From: Richard Aston
Sent: 09 November 2010 09:40
To: Planning
Subject: FW: Response for planning application: N6/2010/2055/MA
Attachments: 20101108 Former Shredded Wheat Factory Welwyn Garden City E.doc

FULL PLANNING PERMISSION FOR PART DEMOLITION, REPAIR, RESTORATION, EXTENSION AND CONVERSION OF THE FORMER SHREDDED WHEAT FACTORY COMPLEX TO PROVIDE RETAIL (A1 & A3), BUSINESS (B1), HERITAGE CENTRE (D1), ENERGY CENTRE, NEW LEISURE CENTRE BUILDING AND CIVIC SQUARE BUILDING INCLUDING RESIDENTIAL AND RETAIL (A1 TO A5). ASSOCIATED ALTERATIONS TO EXISTING VEHICULAR AND PEDESTRIAN ACCESS AND HIGHWAY LAYOUT WITHIN AND AROUND THE SITE, INCLUDING THE CREATION OF TWO VEHICULAR ACCESS RAMPS TO BASEMENT PARKING, HARD AND SOFT LANDSCAPING, THE PROVISION OF A CIVIC SQUARE, PARK, PUBLIC AND PRIVATE OPEN SPACE, PEDESTRIAN WALKWAYS TO INCLUDE THE UPGRADE OF THE EXISTING PEDESTRIAN FOOTPATH OVER THE RAILWAY LINE AND ASSOCIATED ENABLING WORKS. OUTLINE PLANNING PERMISSION FOR DEVELOPMENT OF LAND TO THE WEST AND SOUTH OF THE SHREDDED WHEAT FACTORY TO COMPRISE THE FOLLOWING USES: RETAIL (A1 & A5), BUSINESS (B1), HOTEL (C1), RESIDENTIAL, TO INCLUDE: HOUSES, FLATS, CARE HOME AND YMCA (C2 & C3); DOCTORS SUR

FIRST FLOOR PLAN

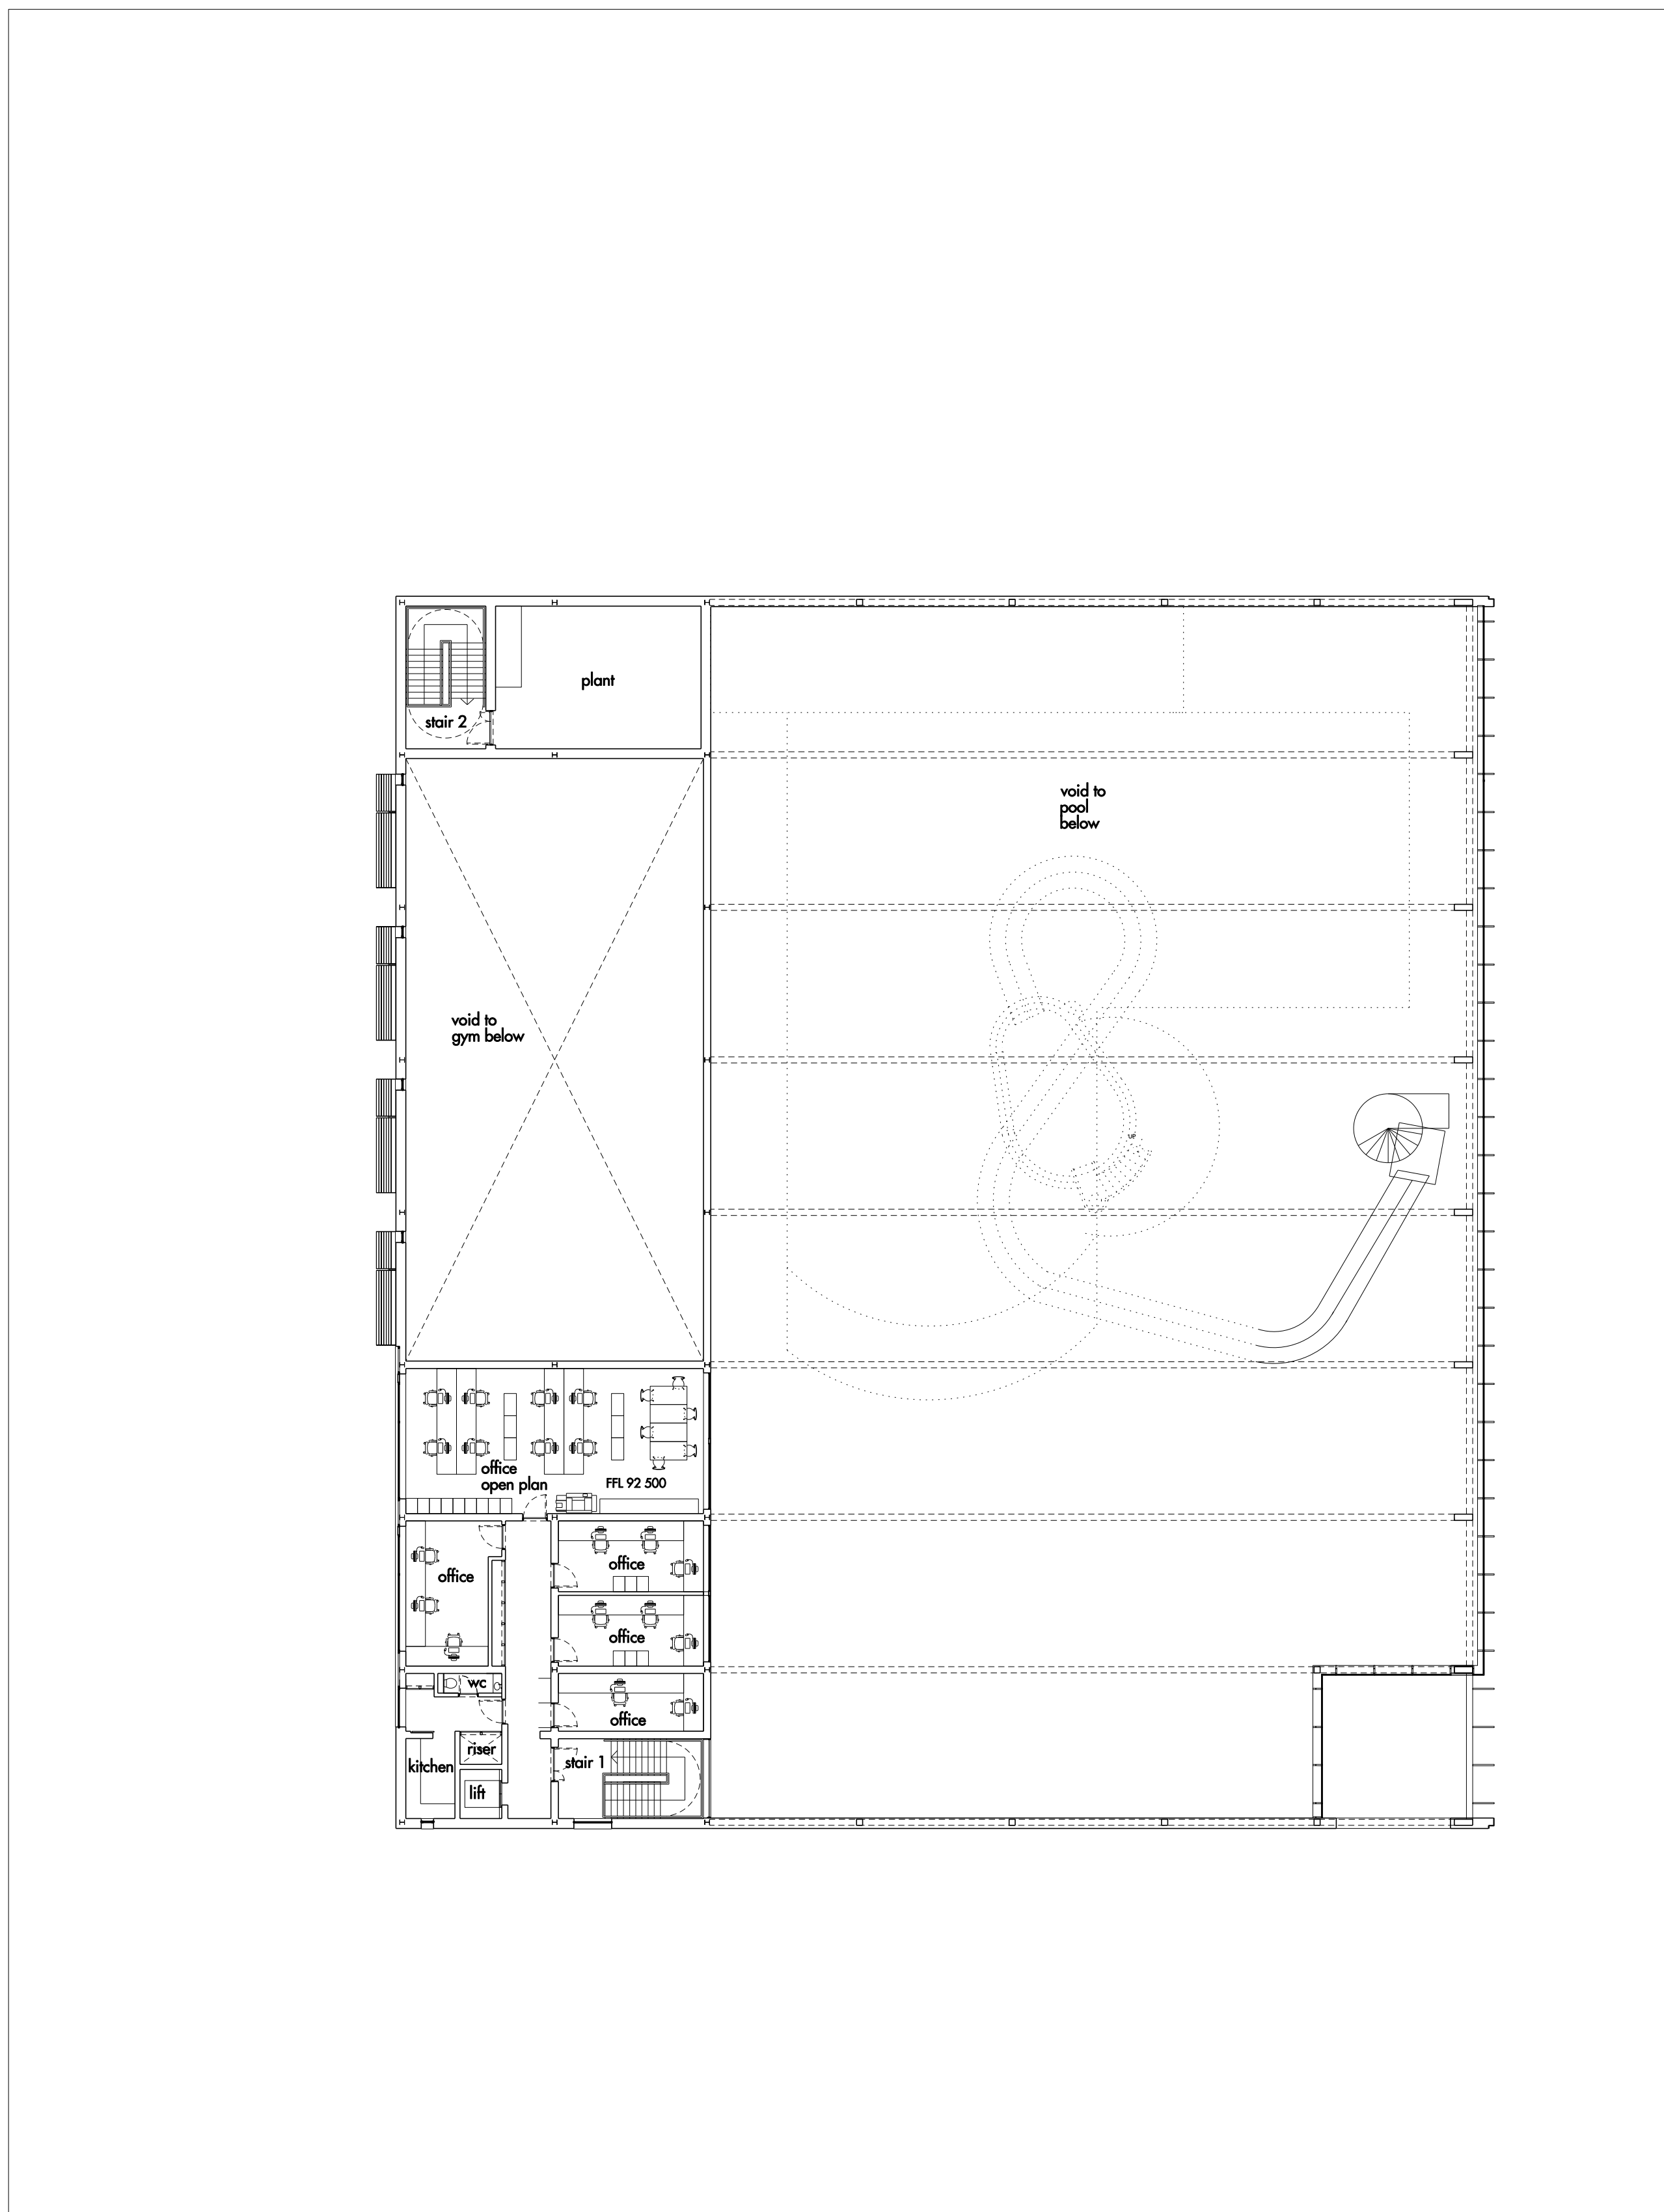
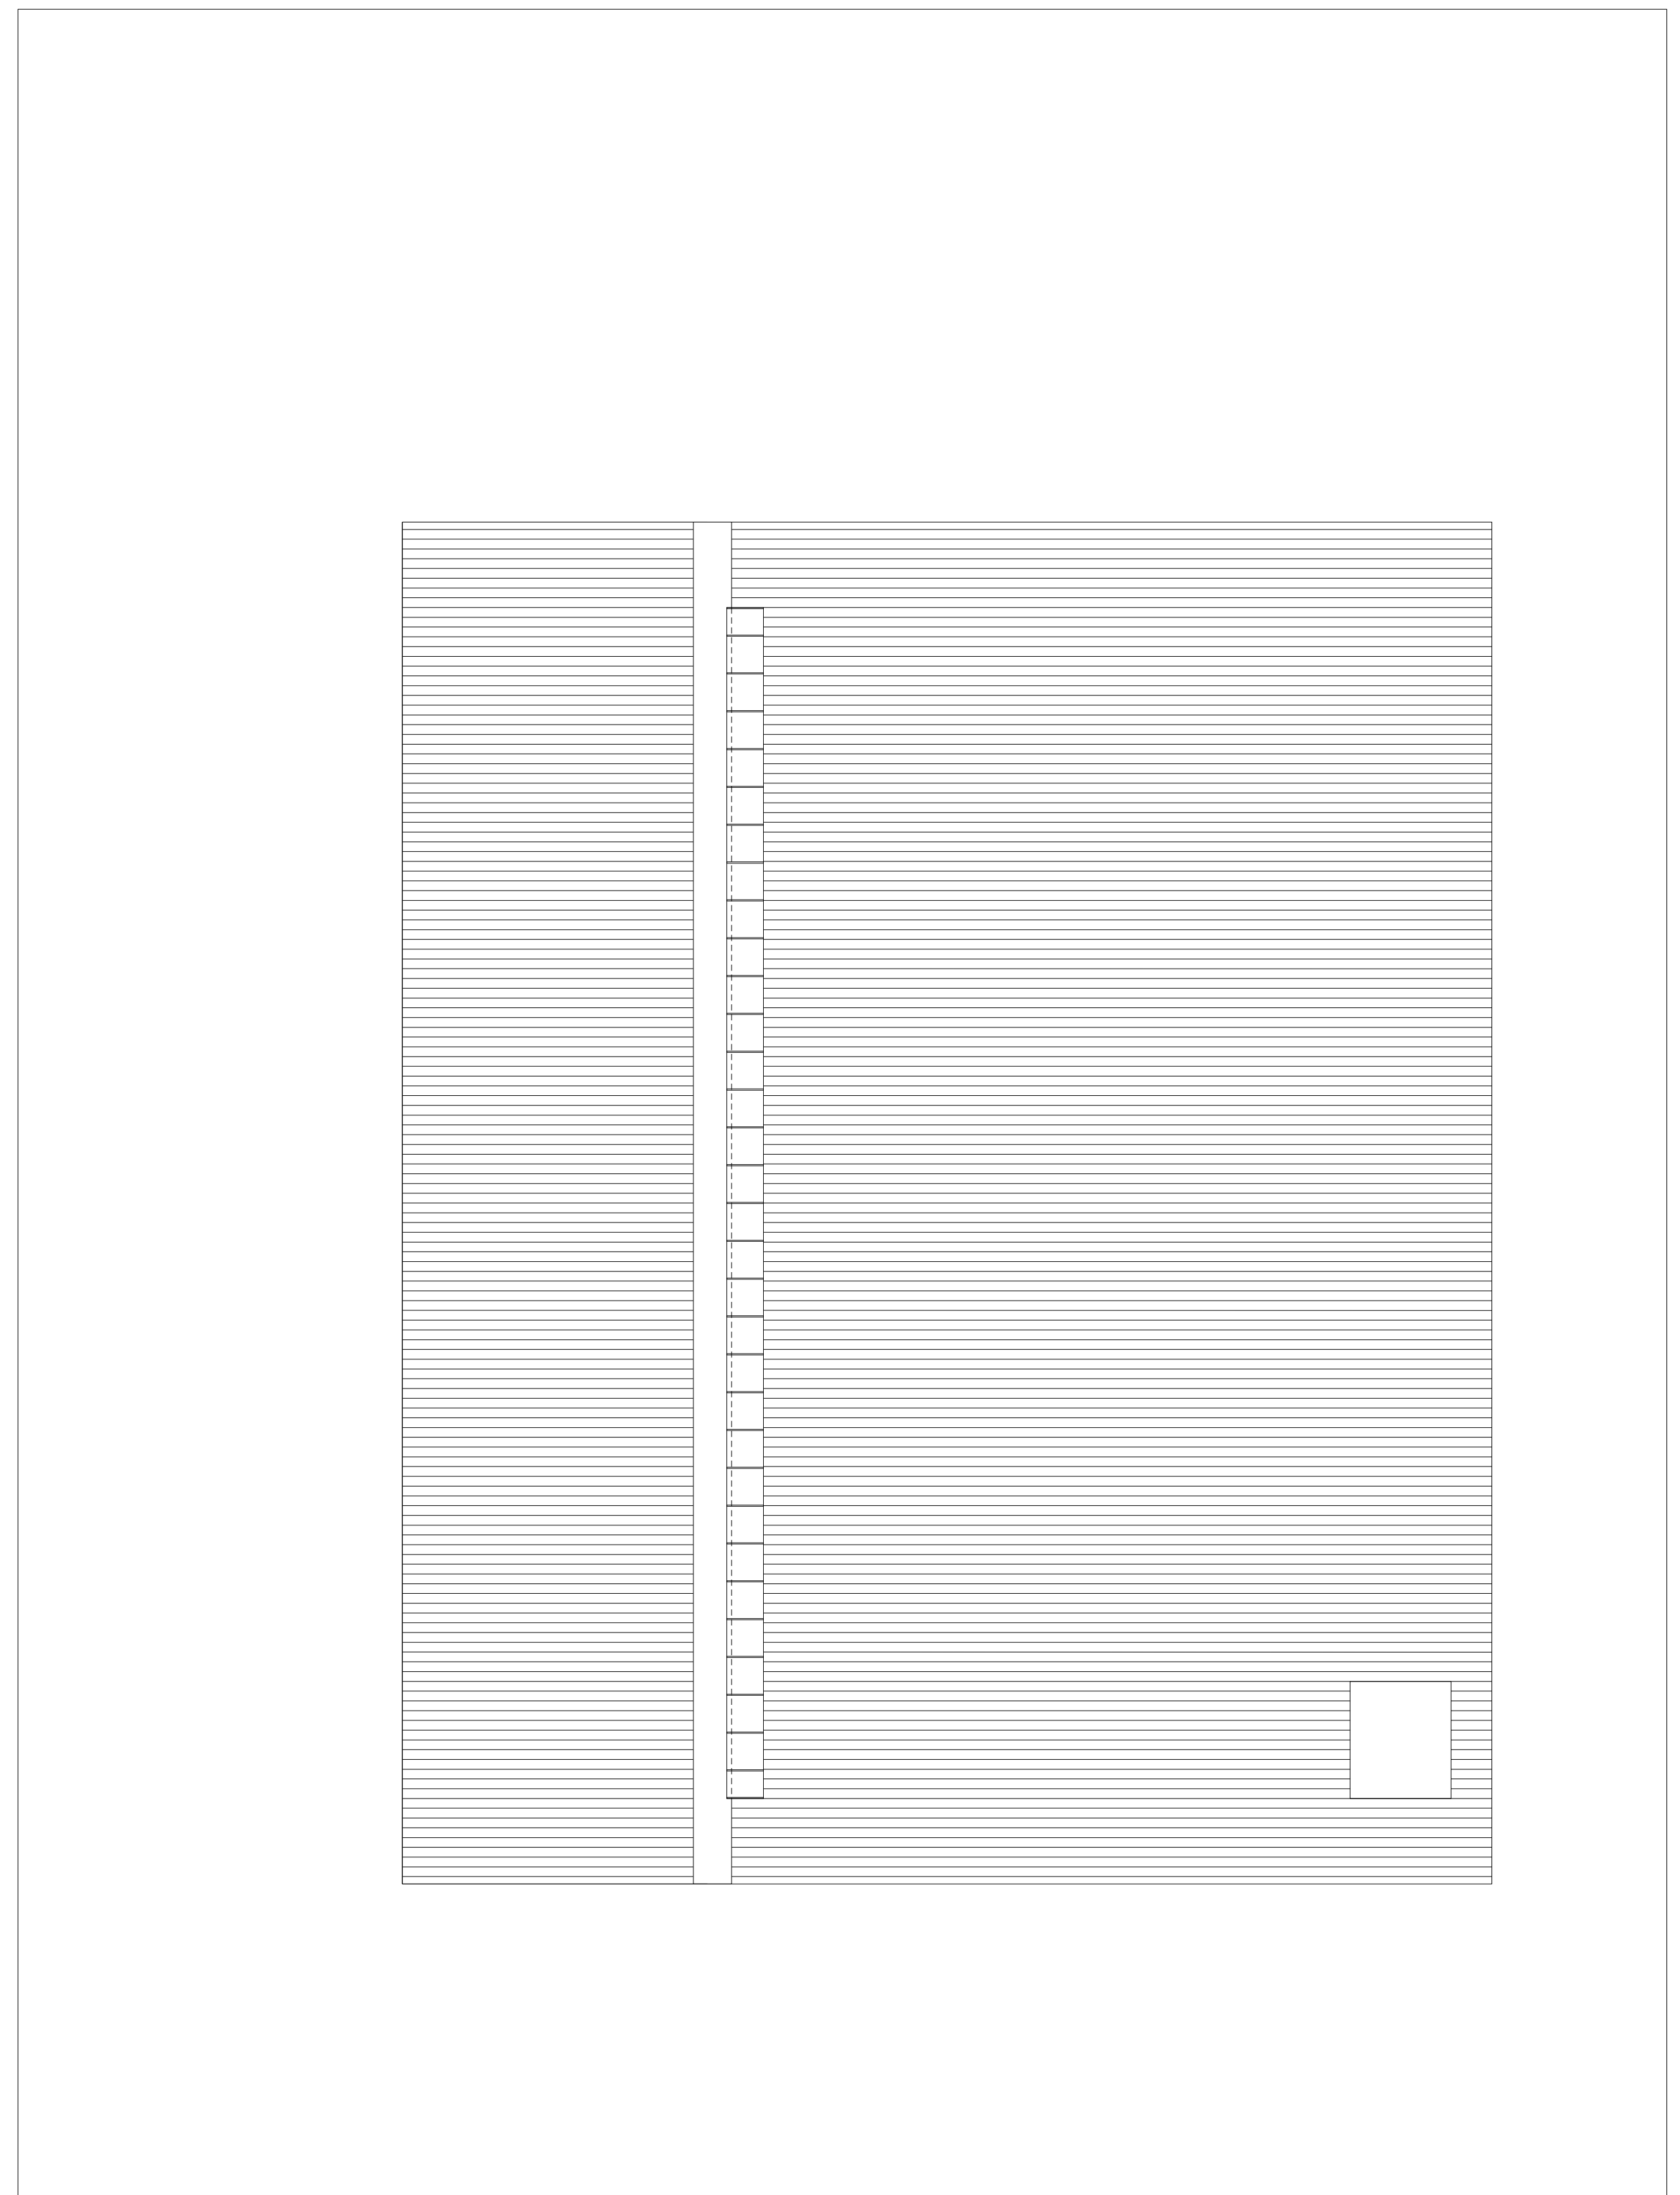
- Sport England promote the use of a draft lobby at the main entrance to aid the reception environment.
- The turnstiles would normally be post reception, in order to allow access to the reception whilst also maintaining control of access to the building
- It is recommended that the first aid room has a direct exit to the outside so that a casualty can be loaded directly into the ambulance. This would require a change of location.

- The pool is currently designed to accommodate both lane and leisure swimming – does this reflect local need? Can the pool deliver on the learn to swim priorities that may be required locally through educational need and community need with the current design?

- If the swimming pool is to remain as proposed it is suggested that the swimming pools would benefit from being the other way round i.e. with the 25m run being parallel to the changing rooms (shallow end at the entrance end). This will allow people that bring other people to learn to swim classes to be able to observe what is happening from the seating in the café area.

- In relation to the 25m section of the pool the flume should be moved so it does not go over this at all (it is thought that there is room to achieve this) and the raised section (labelled events) at the deep end should remain at a similar level (deck level) all around the swimming pool – both of these points relate to access and sight lines for staff, particularly when the swimming pool is in use for club/teaching, when good contact between staff on the poolside and those in the water is required

- The proposed width of the 25m section of the pool is 12m. Sport England's Swimming Pool Design guidance document (referenced above) recommends that the width of a 6 lane pool should be 13 metres wide while the width of a 5 lane pool should be 10.5 metres

- It would appear that spectators are encouraged to be on poolside and use toilets that lead from the pool surround. It can not be understood from the detail provided how these areas are separated (if at all) but this would encourage contamination, as would the food serving area, into the wet side if not carefully managed

- Changing spaces – the current level of provision is 94 plus group change. Based on the volume of water space provided approximately 190 change spaces are needed to cope with average demand. This is based on the calculation model identified in the guidance (link provided above). This needs to be considered alongside the programming of the facility to feel confident that any final proposals can accommodate user numbers.

- Toilets - In terms of toilet provision, the current level of provision is 13 WC's and 6 urinals. For the amount of water space proposed 10 WC's and 6 urinals are required.

- Showers – currently 17 are provided, this could be rationalised to 12 to 14. It is recommended that all showers are provided in central areas and not within toilet areas. This means that they

are accessible by all. It is advantageous to provide some of the showers are cubicle showers to aid privacy. Showers should be centrally located to facilitate both pre and post swim usage.

- An accessible change is required in wet side area.

- An accessible change is required in dry side and not just a toilet.
- In terms of layout this is not ideal. The toilets should be accessed first. This allows those users who are not getting changed to access the toilets. This then leads to the change area with showers at the rear. With the current proposed layout anyone wishing to use the toilet will have to access the change

- In terms of capacity, the usable space in each is around 34 (this is presuming that each square within the changing rooms on plan Detailed Proposals: Leisure Centre (Building A) Proposed Plans (568_07_210) are changing spaces as apposed to lockers). 1 change space per gym station or 1 change space per 5 sqm of gym floor space are the recommended ratios. The proposed dry side changing areas therefore currently represent an over provision

- There are currently 6 showers proposed. 1 shower per 6 change spaces is the recommended ratio. The proposed provision of showers therefore currently represents an under provision (as mentioned above, this is presuming that each square within the changing rooms are changing spaces as apposed to lockers)

- Lockers – these can be provided within the change area or outside. It is recommended to provide small valuables lockers externally to facilitate those not using the change area. Lockers should not be provided behind the changing spaces as this compromises access at peak time. There should be 2.5 lockers per change space to allow for change overs and a number of lockers being out of use. Accessible lockers need to be provided outside of the accessible change

- Natural light should be encouraged whilst avoiding glare
- Views over the pool should be included where appropriate (whilst being aware of child protection issues)
- A plumbed in water fountain should be included to serve the gym

- The toilet located on the second floor needs to be accessible

- There is significant office space on the second floor. This may be useful for centre and local club usage but this needs to be clarified as it is a significant expense to the scheme.
- In relation to the long term sustainability of the proposed Leisure Centre to may be useful to consider the mixture of facilities included i.e. would the inclusion of a larger gym or a dance studio be beneficial from a revenue generation perspective?
